Portishead Branch Line (MetroWest Phase 1)

Planning Inspectorate Reference: TR040011

9.3.7 ExA.SoCG-NSLIDB.D3.V2 - Statement of Common Ground

Between:

1. All dimensions are in metres unless noted otherwise.

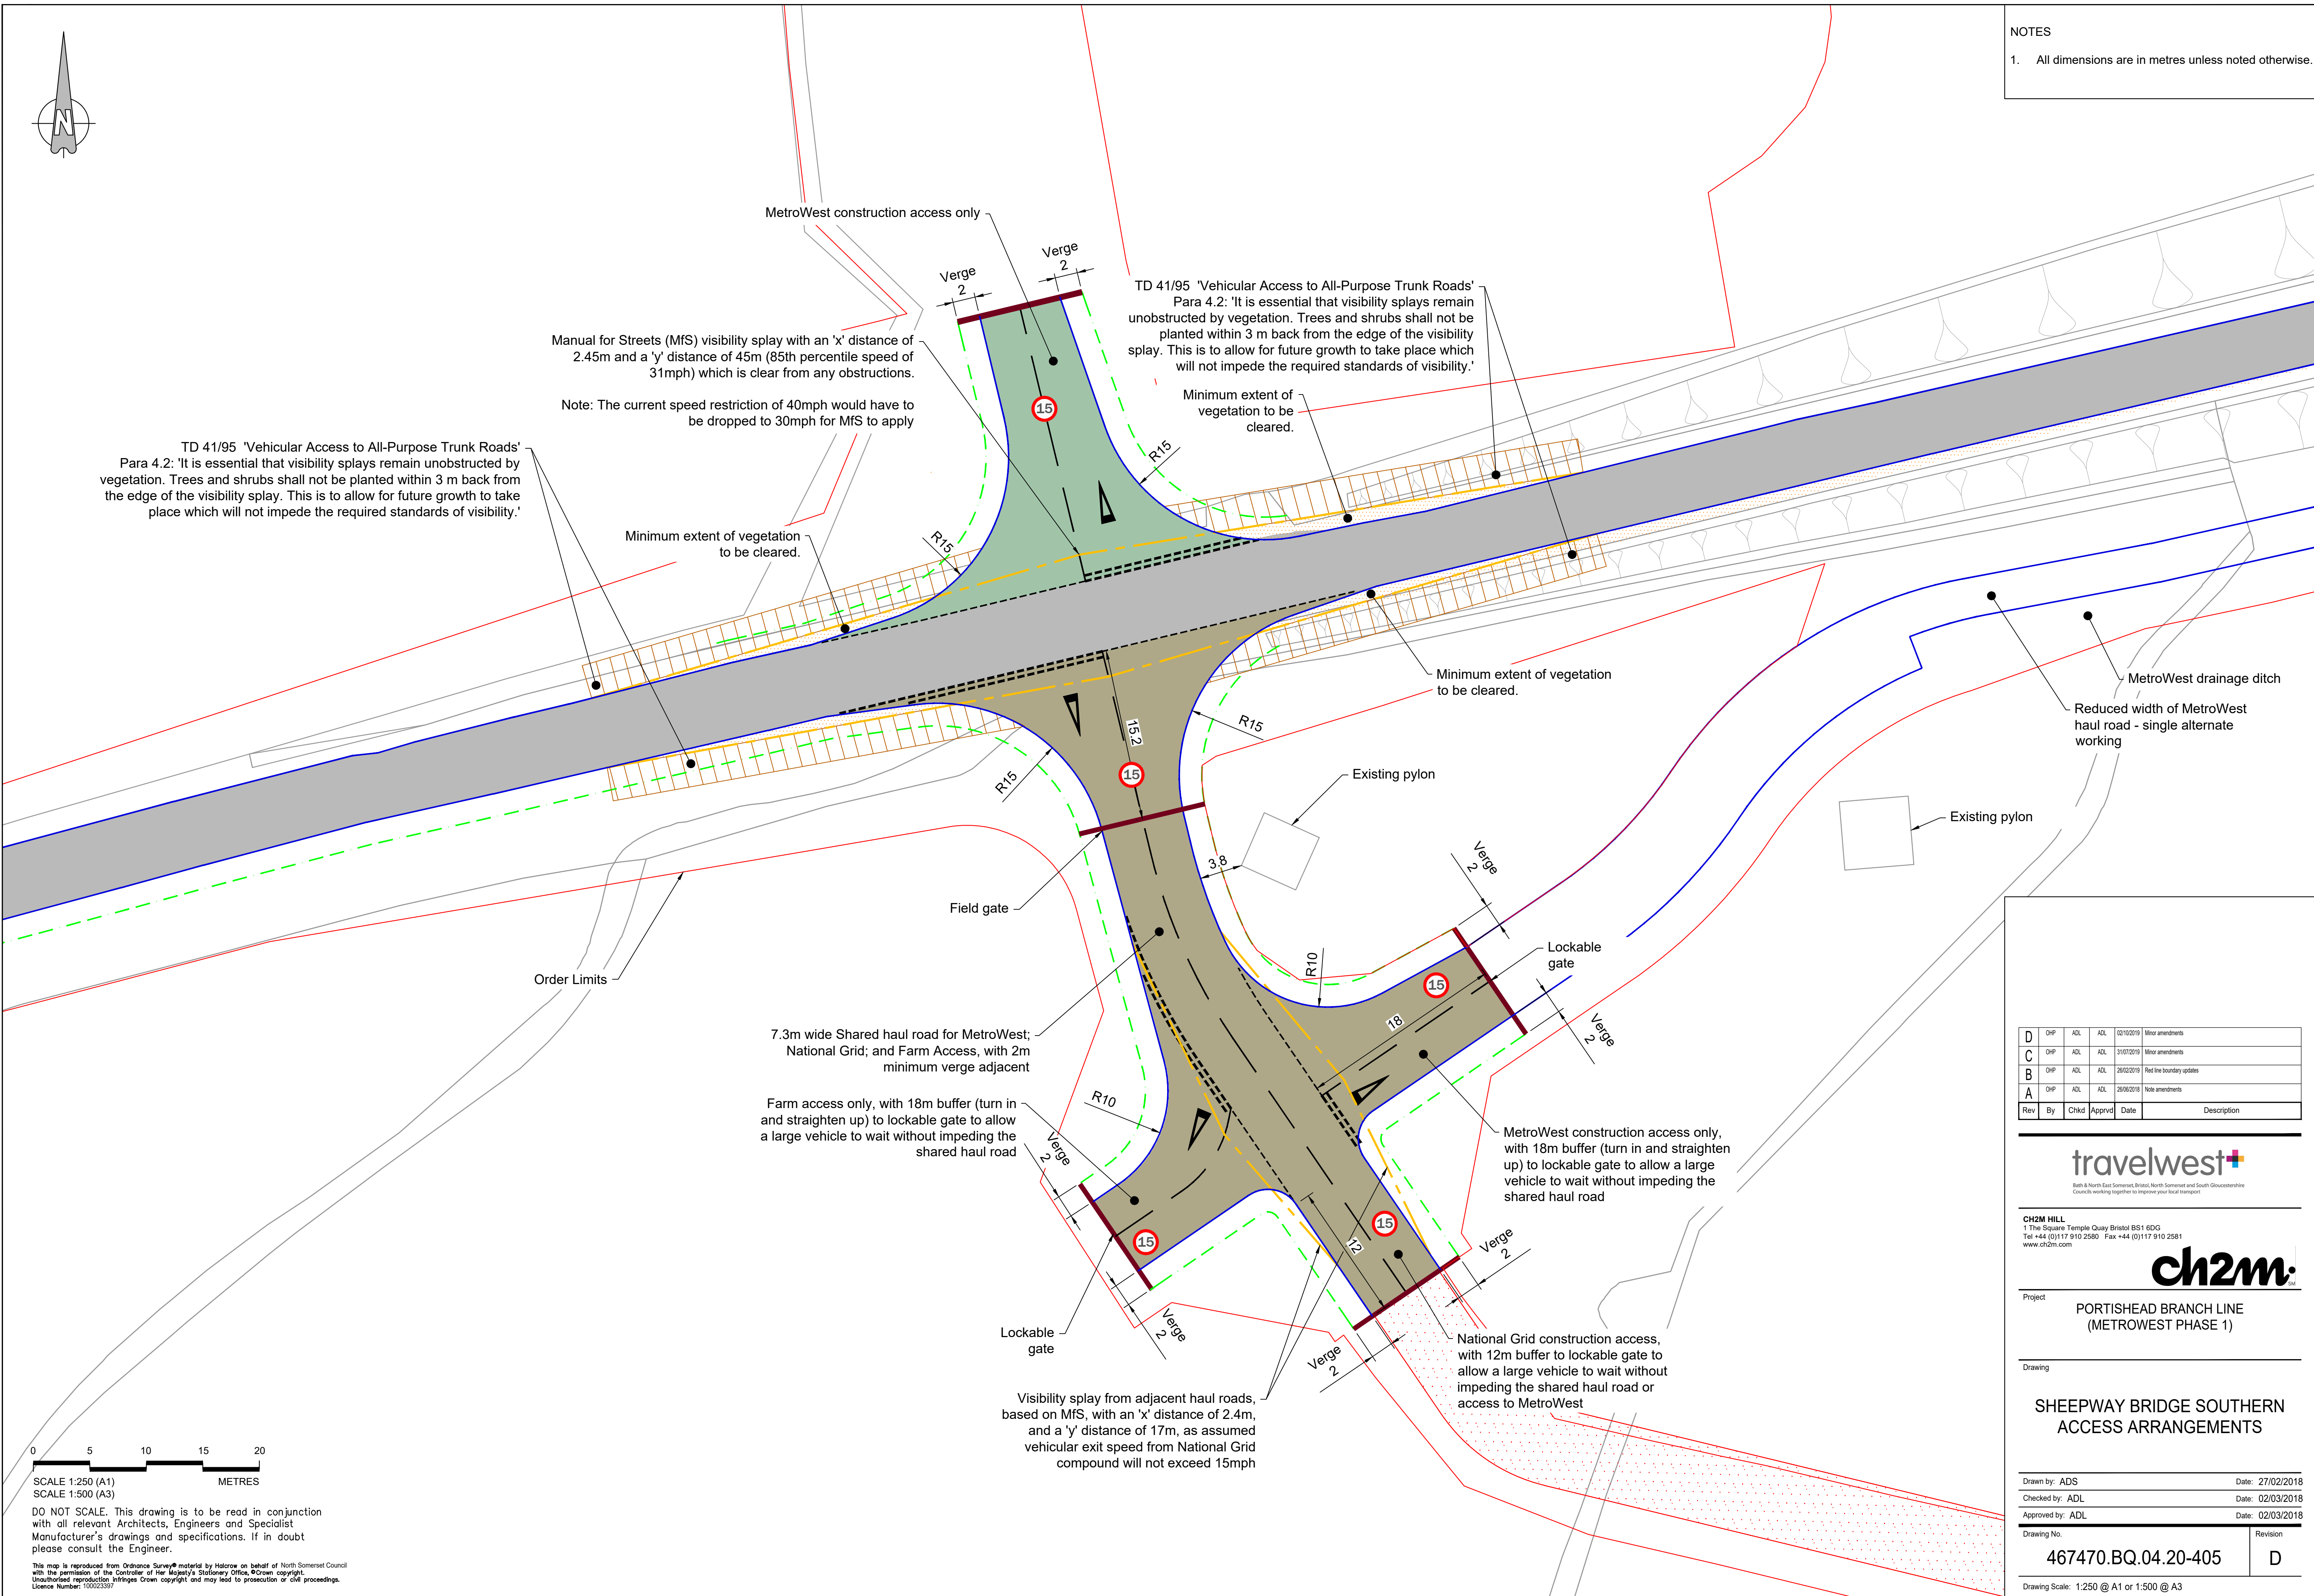
IDB1.10P	Water Resources , Drainage and Flood Risk	Stated a need for a method of the NSLIDB legally securing access to the proposed NR compound at Sheepway.	The latest highway drawing (DCO Document Reference 2.49) for the Sheepway area was issued to the NSLIDB and it was stated that there may have been a misunderstanding between what NR need on a temporary and permanent basis. On a temporary basis (during construction) the NR compound will indeed prevent access for the NSLIDB. However, post-construction the existing access route that the NSLIDB has used in the past in that location will be reinstated, albeit in a slightly different alignment to go around the NR compound track. We believe this represents a betterment on	Agreed
		Sneepway.	have been a misunderstanding between what NR need on a temporary and permanent basis. On a temporary basis (during construction) the NR compound will indeed prevent access for the NSLIDB. However, post-construction the existing access route that the NSLIDB has used in the past in that location will be reinstated, albeit in a slightly different alignment to go around the NR compound

NSDC currently clear the ditches in this area and will be able to do so during construction as they use a different access from the north west (via

Portishead) – this separate access will be unaffected by the DCO Scheme.	
IDB1.11P	Water Resources , Drainage and Flood Risk	Requested location specific outfall details of temporary and permanent drainage features that include invert levels and a check on the downstream connectivity of the receiving watercourses. Stated all that currently appears on drawings is an indication of flow rates; however, stated that the flows are acceptable.	The detailed design stage will be completed when it is known what the contractor's plans are for using the haul roads and compounds. The Surface Water Drainage Strategy (DCO Application Document Reference 6.26) has assumed a worst case (i.e. 100% coverage with an impermeable surface) which in reality is unlikely to be the case, in the calculations.	Agreed
IDB1.12P	Water Resources , Drainage and Flood Risk	Requested details of temporary culverts for the haul road, compounds, site construction areas etc. with location specific sizes and invert levels.	This level of detail is not available until detailed design as it will need to be provided to the contractor with options as to how they deliver the scheme with the land available. The Surface Water Drainage Strategy (DCO Application Document Reference 6.26) sets out a worst case scenario for flow rates and suggested ways to manage the flows and the calculations and possible locations of these are contained within it.	Agreed
